Application Ref:		3/2025/0850		 Ribble Valley Borough Council www.ribblevalley.gov.uk
Date Inspected:	N/A	Site Notice:	N/A	
Officer:	EP			
DELEGATED ITEM FILE REPORT:				APPROVAL

Development Description:	Certificate of Lawfulness for proposed erection of a canopy.
Site Address/Location:	1 Mersey Grove Clitheroe BB7 2FQ.

PROPOSED NORTH WEST ELEVATION
Scale 1:100

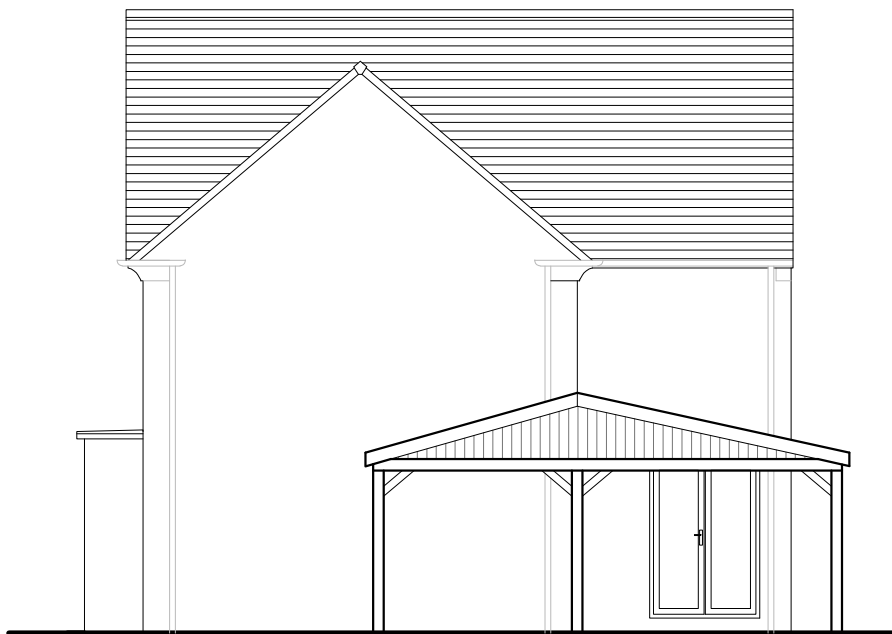
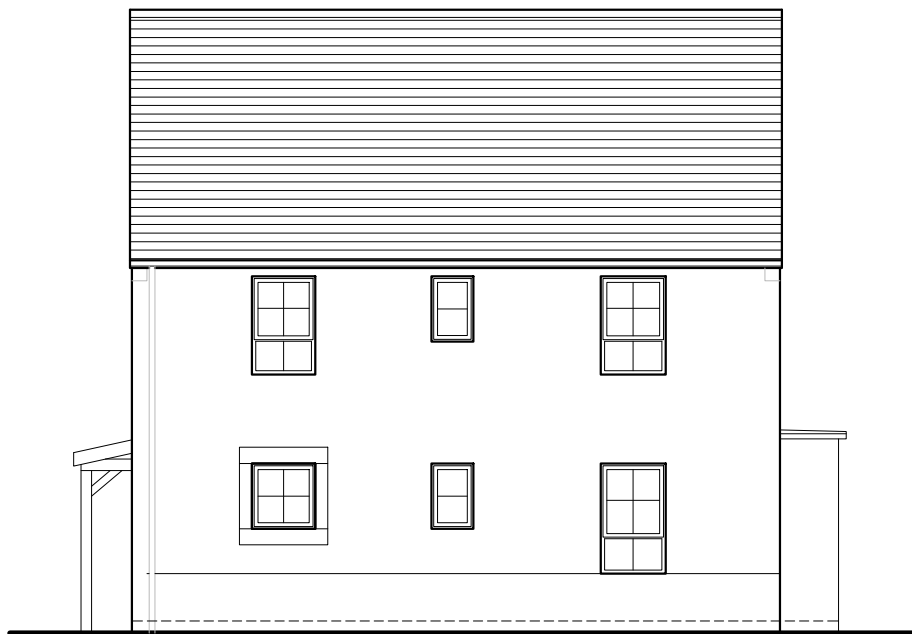
The height of the proposed single storey extension would not exceed the height of the existing dwelling.

The height of the eaves of the proposed extension would not exceed the height of the eaves of the existing dwellinghouse.

The proposed rear extension extends beyond the rear elevation of the dwelling by approximately 3.5m with a maximum height of 3.2m.

The proposed single storey extension will not exceed 3 metres in height to the eaves.

The proposed pergola would be constructed in timber, polycarbonate sheets and roof tiles. Given the nature of the development, the structure is considered akin to a conservatory. On that basis, the materials don't need to directly reflect those found on the application dwelling.

PROPOSED GROUND FLOOR PLAN
Scale 1:50

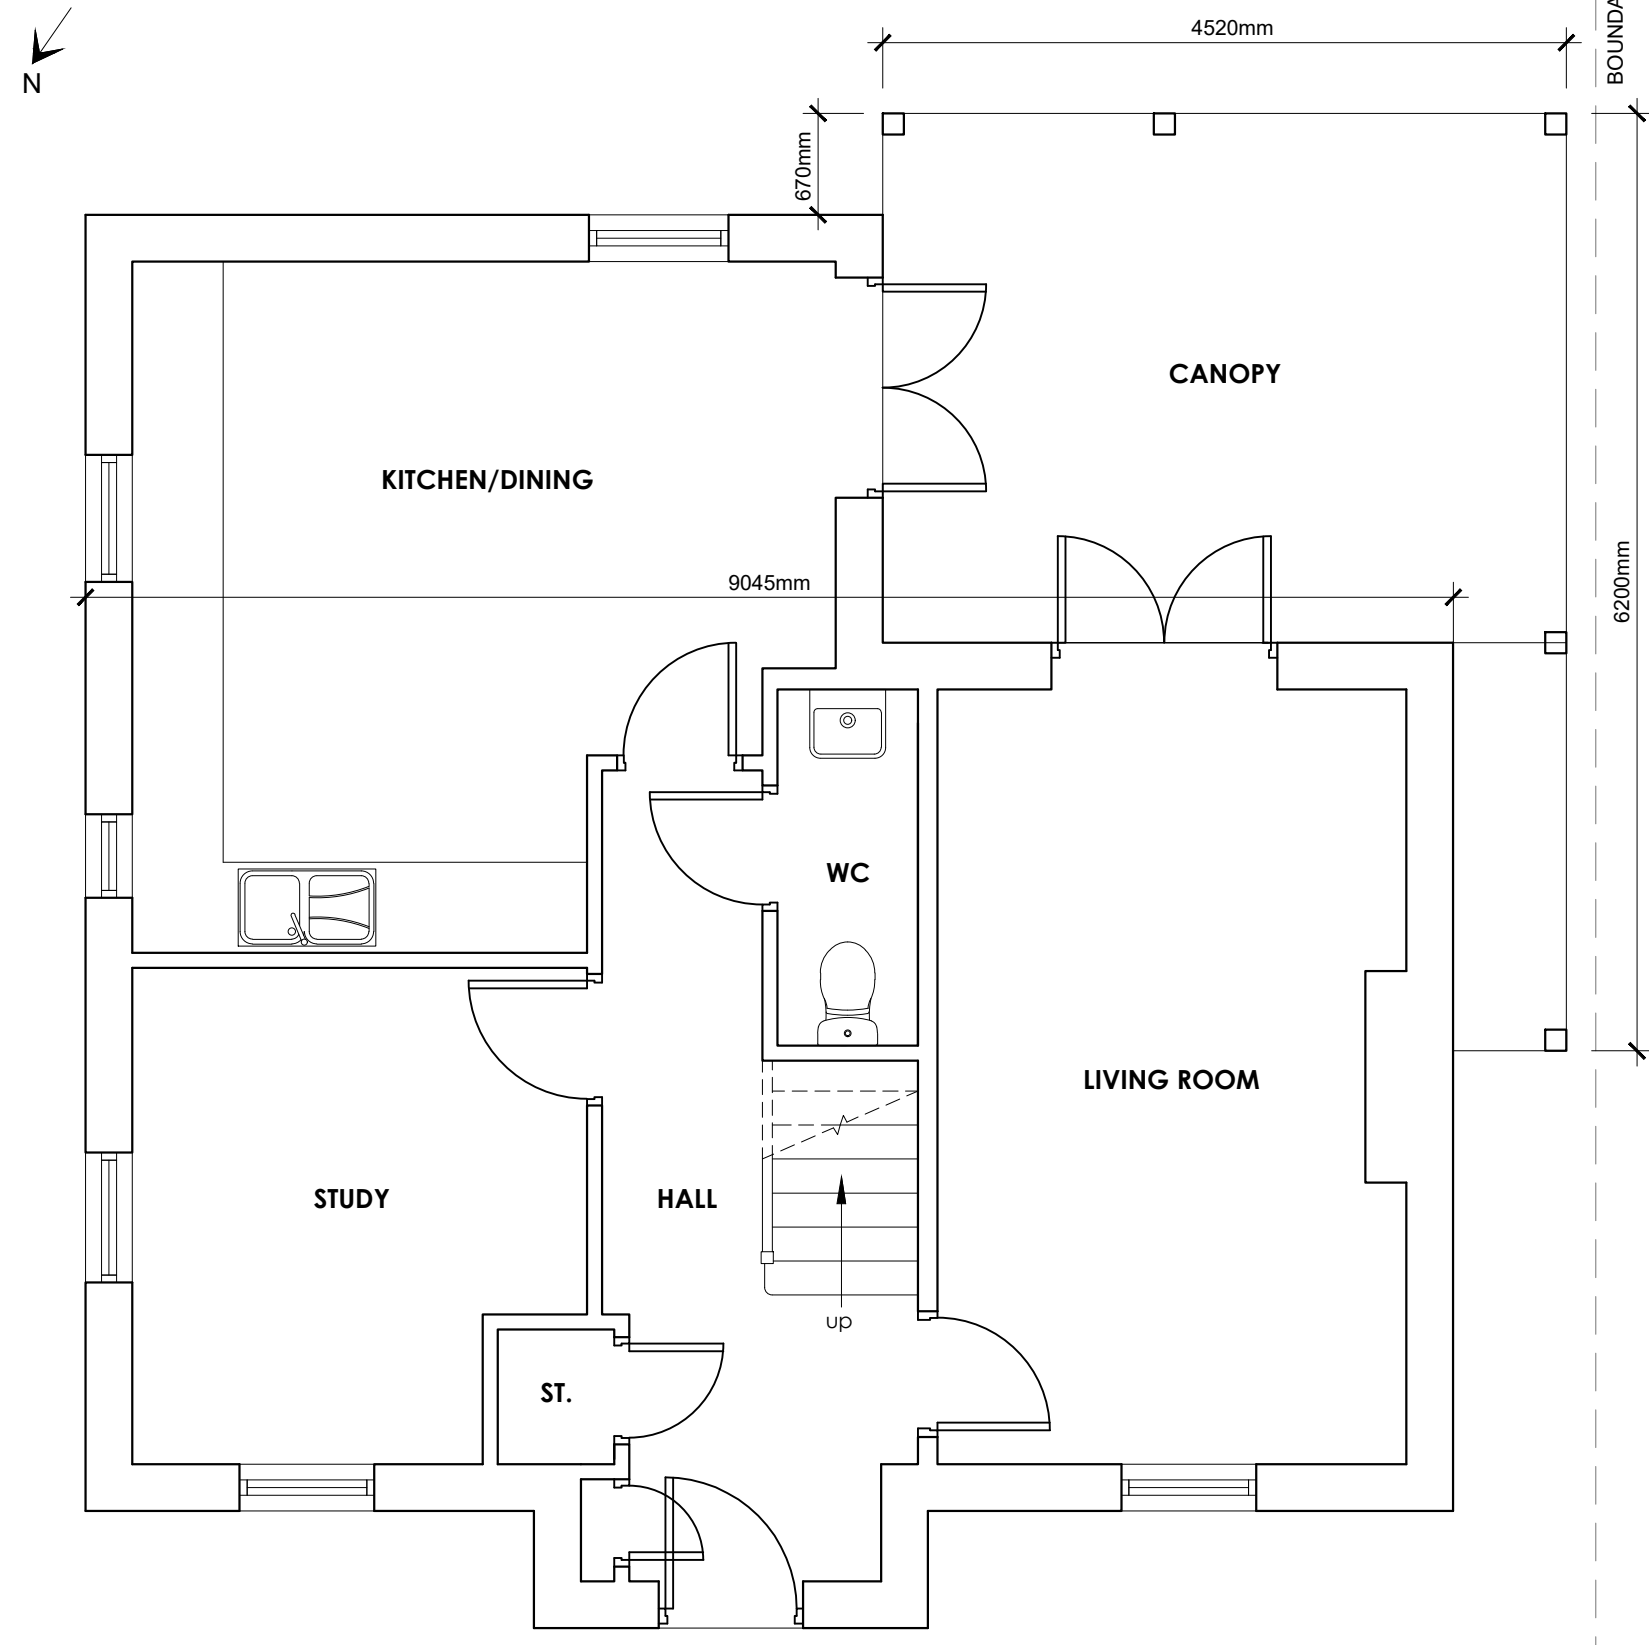
The proposed single storey extension would not extend beyond a wall which forms the principal elevation of the original dwellinghouse or fronts a highway and forms a side elevation of the original dwellinghouse.

The proposed extension does feature a sideways projection but does not exceed 4m in height and has a width that is not greater than half the width of the existing house.

PROPOSED SITE PLAN
Scale 1:200

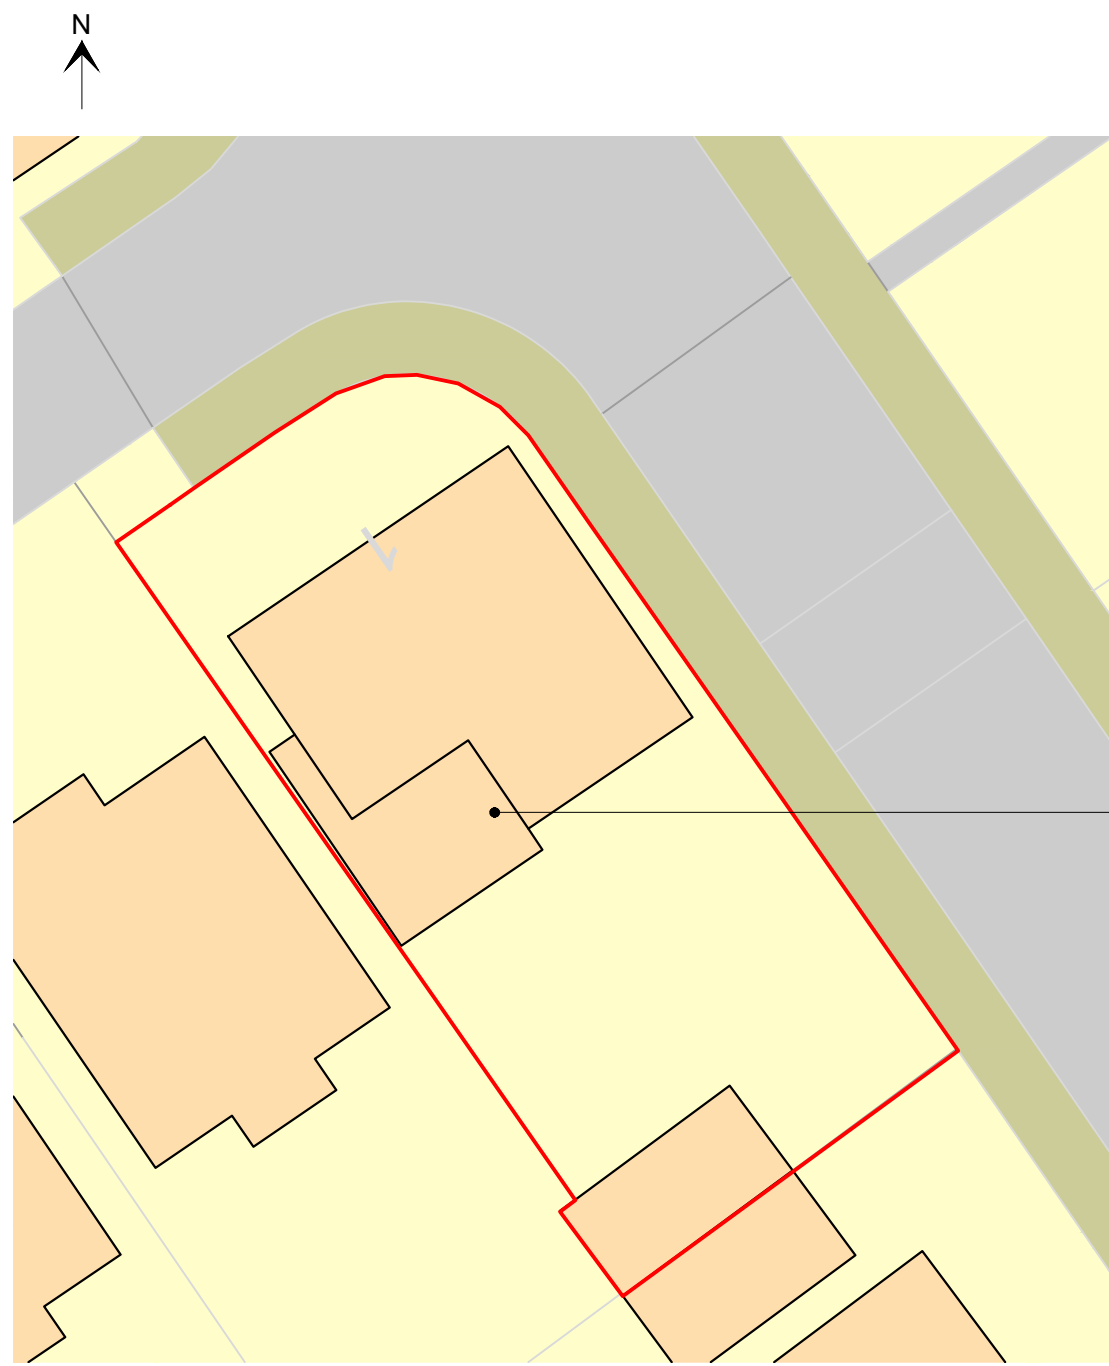
The single storey extension would not exceed 50% of the total area of curtilage of the property.
